## KITTITAS COUNTY COMMUNITY DEVELOPMENT SERVICES

### **RE: Transmittal of Comments – VA-19-00001 Berlin Variance Transmittal of Comments**

Berlin Residence  
 Kitzbuhel Place (TPN 088335)  
 Snoqualmie Pass, WA 98068

A1.0

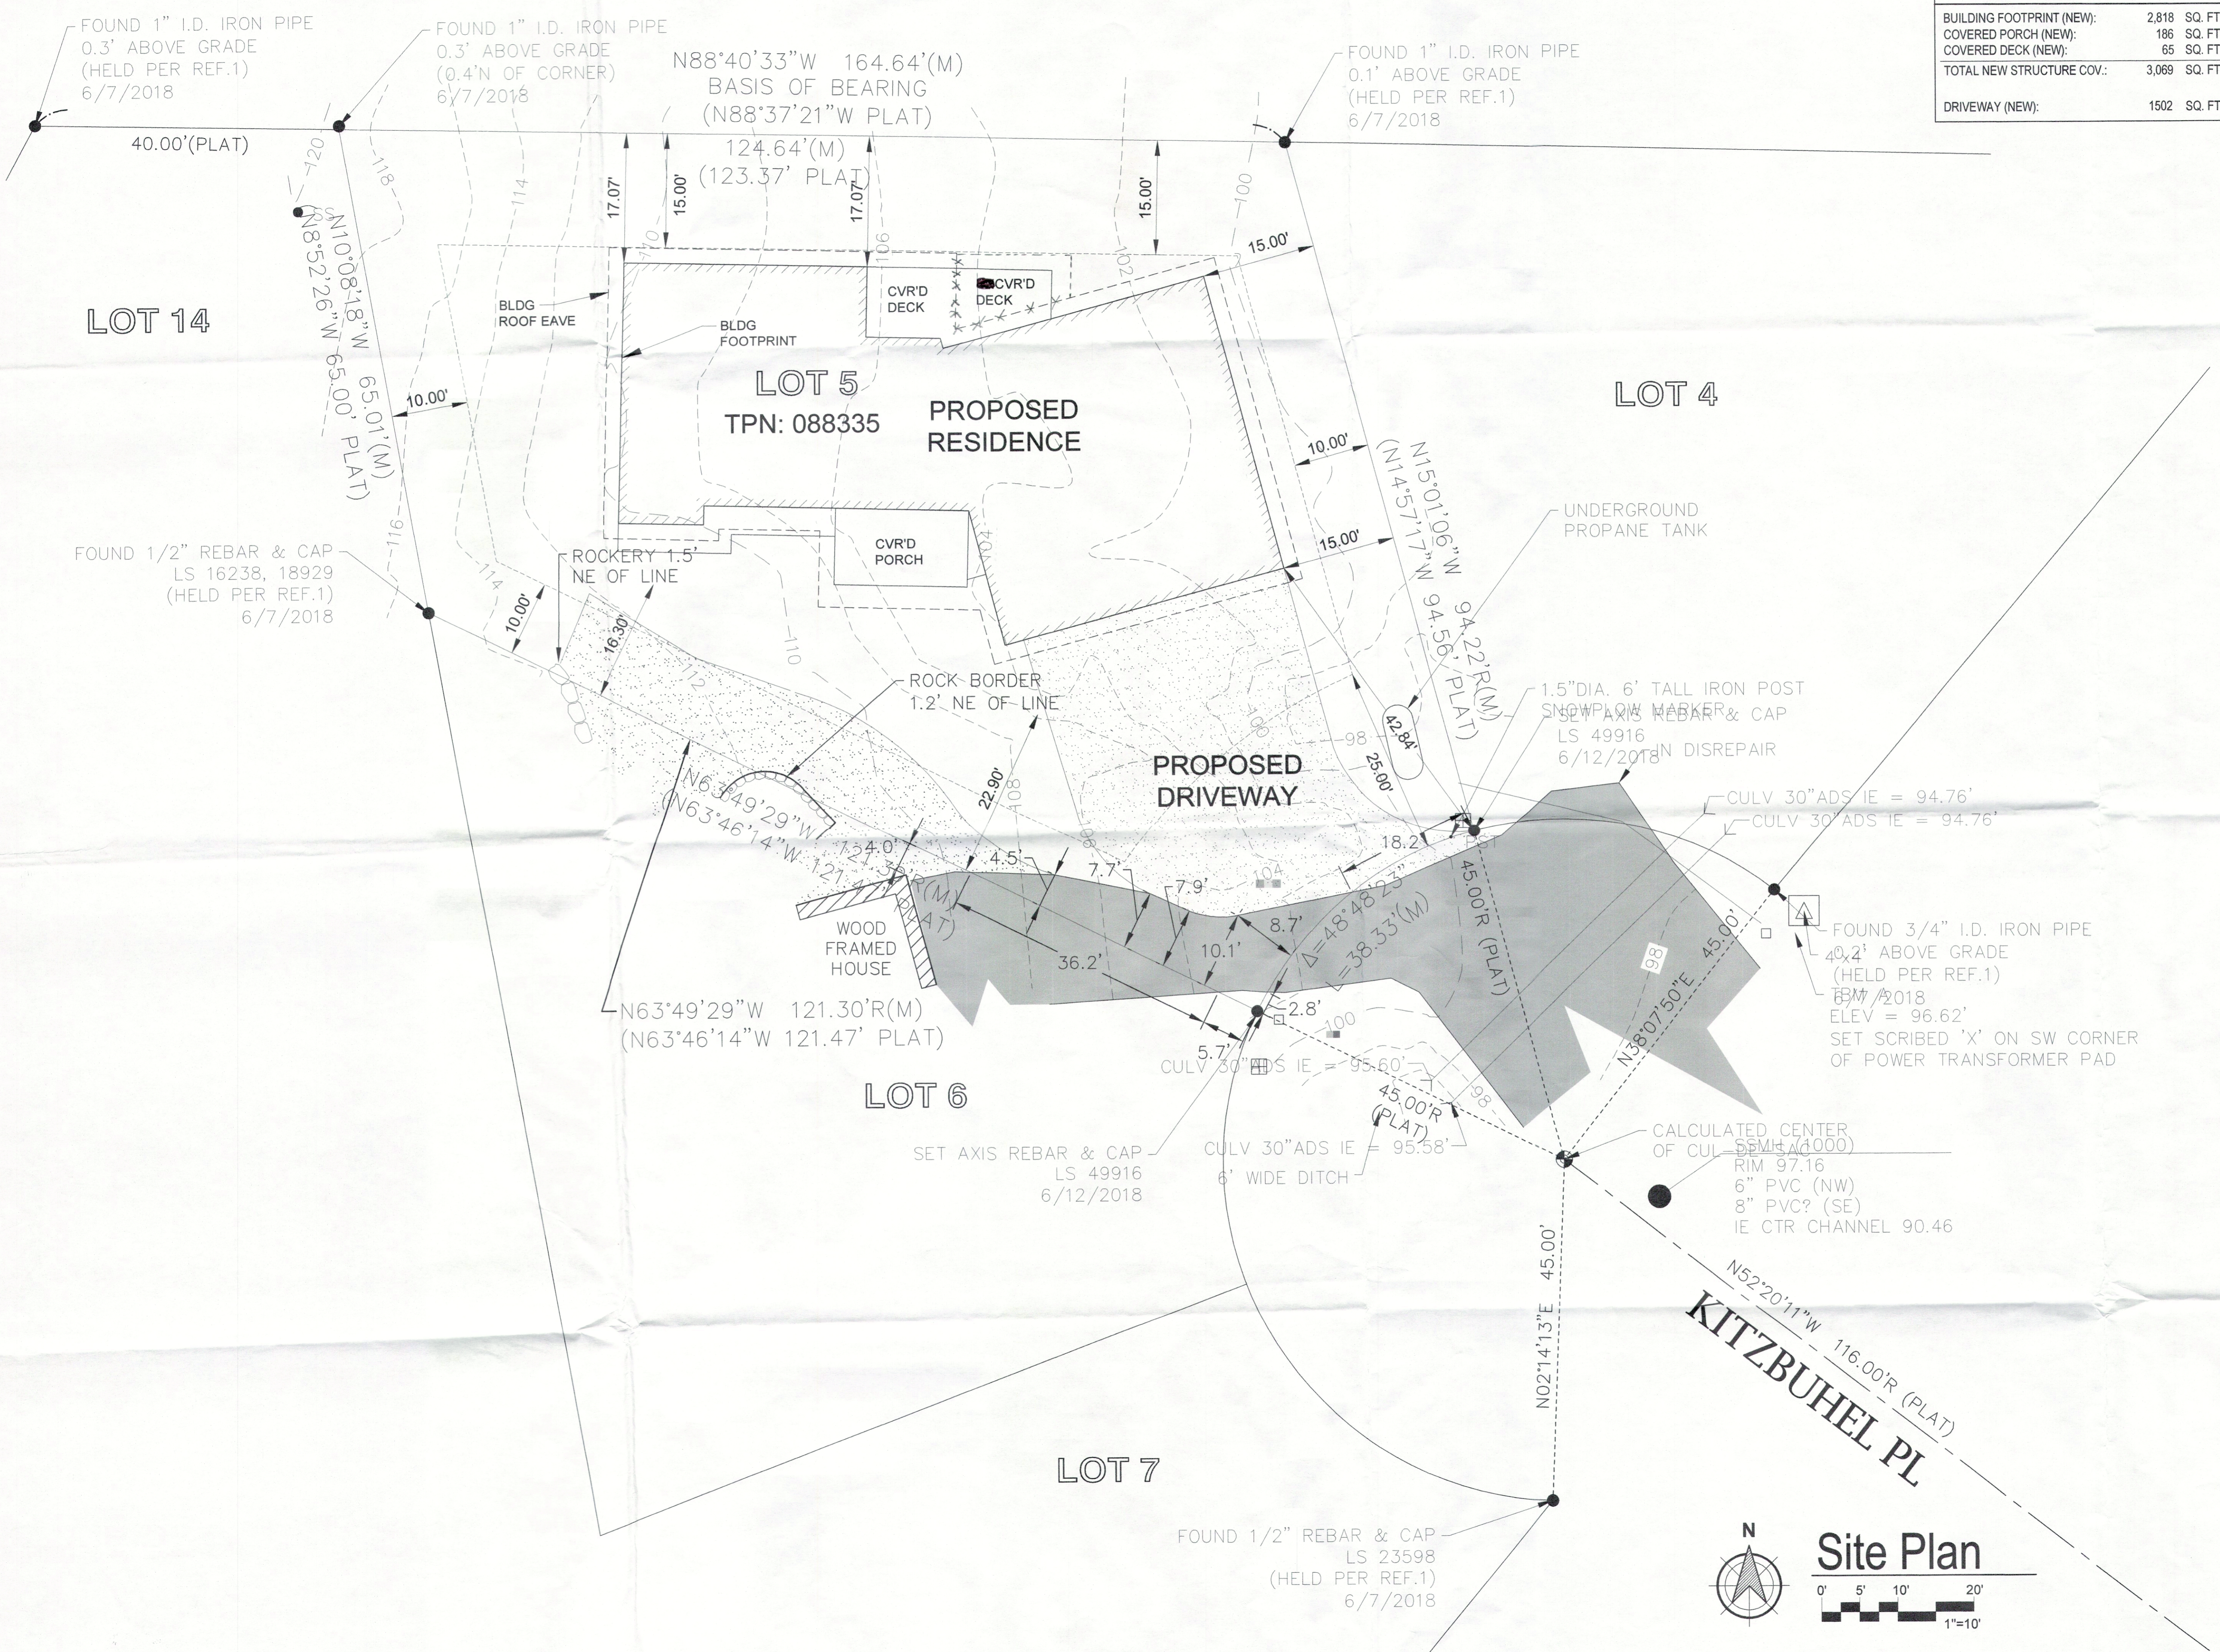
The documents on the server have not been prepared by a surveyor per Dusty Pilkington's request. From the information I can glean from the site plan, it appears that a surveyor was involved (AXIS – PLS#49916), but this is not their original work.

I would also be prudent to have the applicant confirm that the utility lines located at the back of the subject parcel do not have an easement they will be encroaching upon. Their surveyor should be able to confirm this from their title report.

While not relevant to survey, the existing footprint CAN fit on the existing lot holding to the existing setbacks. Please see attached sketch.
